From: Sara Jane [REDACTED]
Sent: 30 September 2019 12:57
To: Amber Willard <Amber.Willard@arun.gov.uk>
Cc: Stephen Wood [REDACTED] Stephen Wood [REDACTED]
Subject: Re: aw/250/19/hh

I am the officer on your application AW/250/19/HH at 19 Kingsway.

Proposed

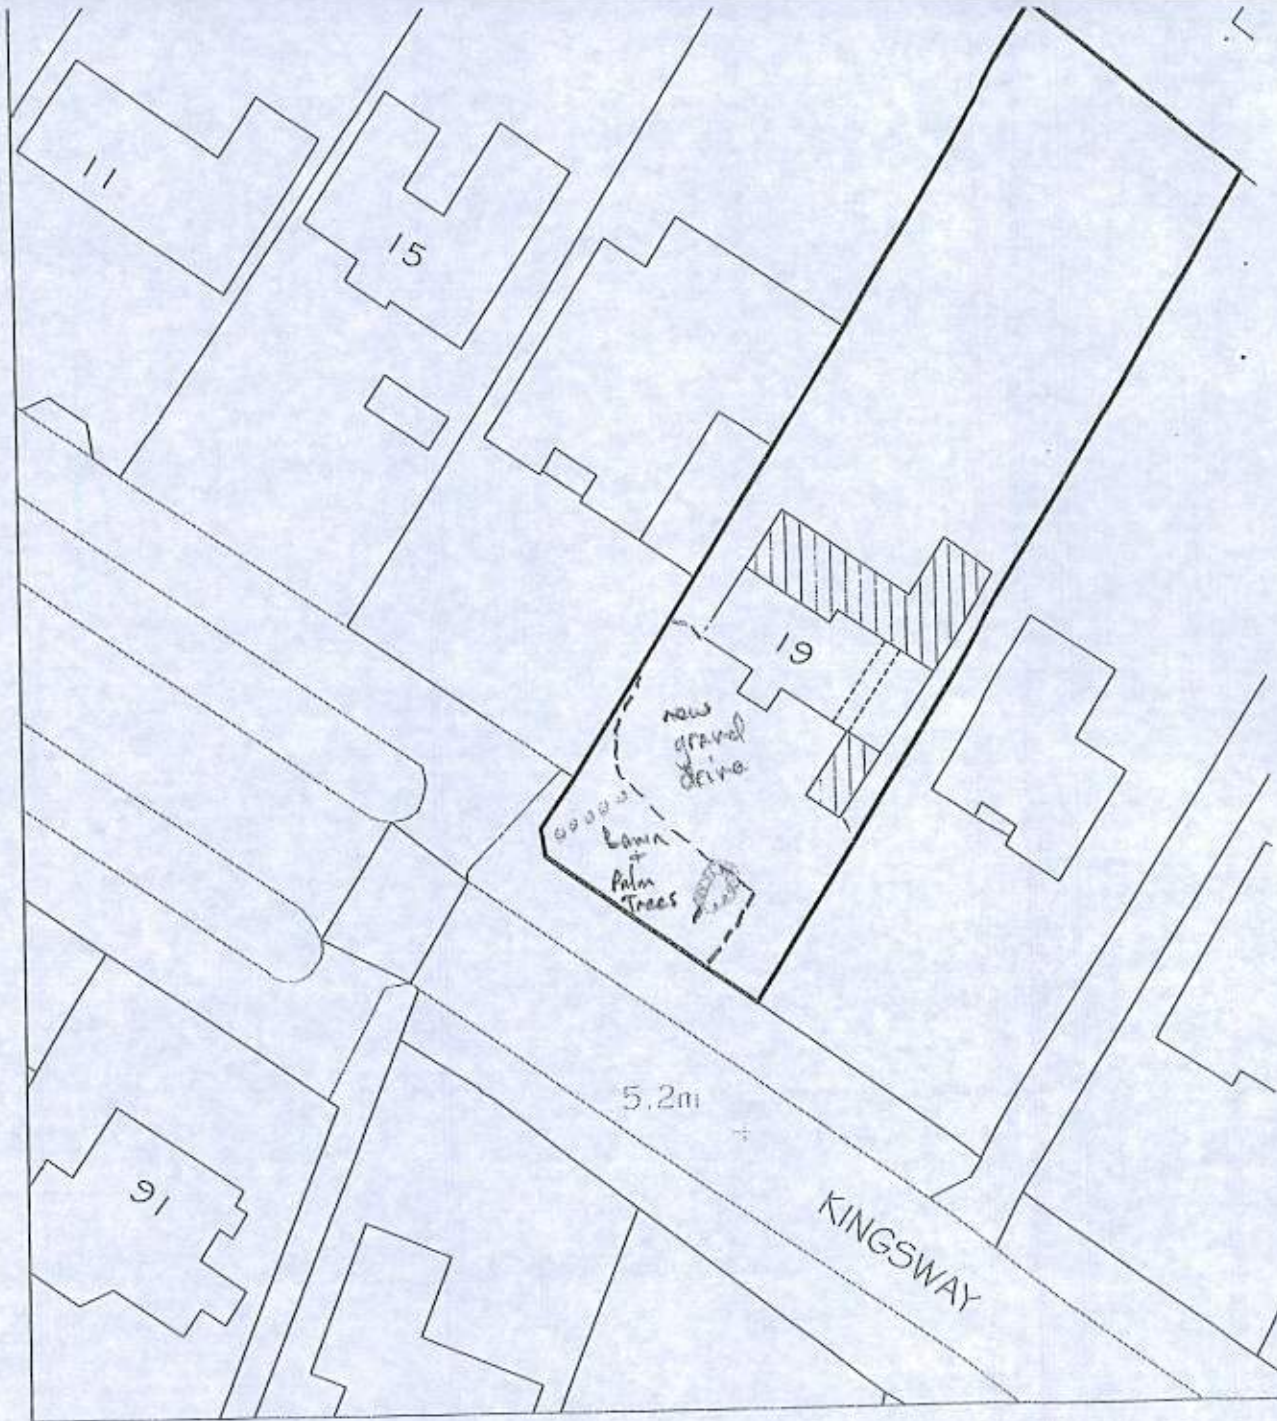
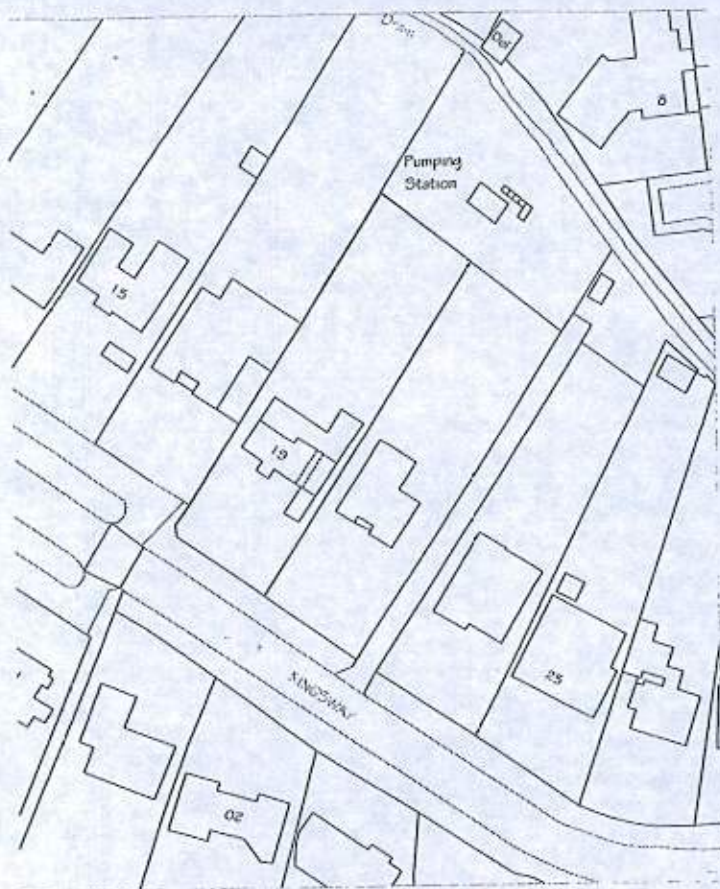
On the plan it shows the gate posts to be increased in width to 3.5m, however in the statement it says they will be increased to 2.5m.

Please can you confirm the proposed width.

The driveway gate proposed width is to be increased from 2m to 2.5.
The curb is already 2.5m so the increased gateway does not affect the entrance from the road.
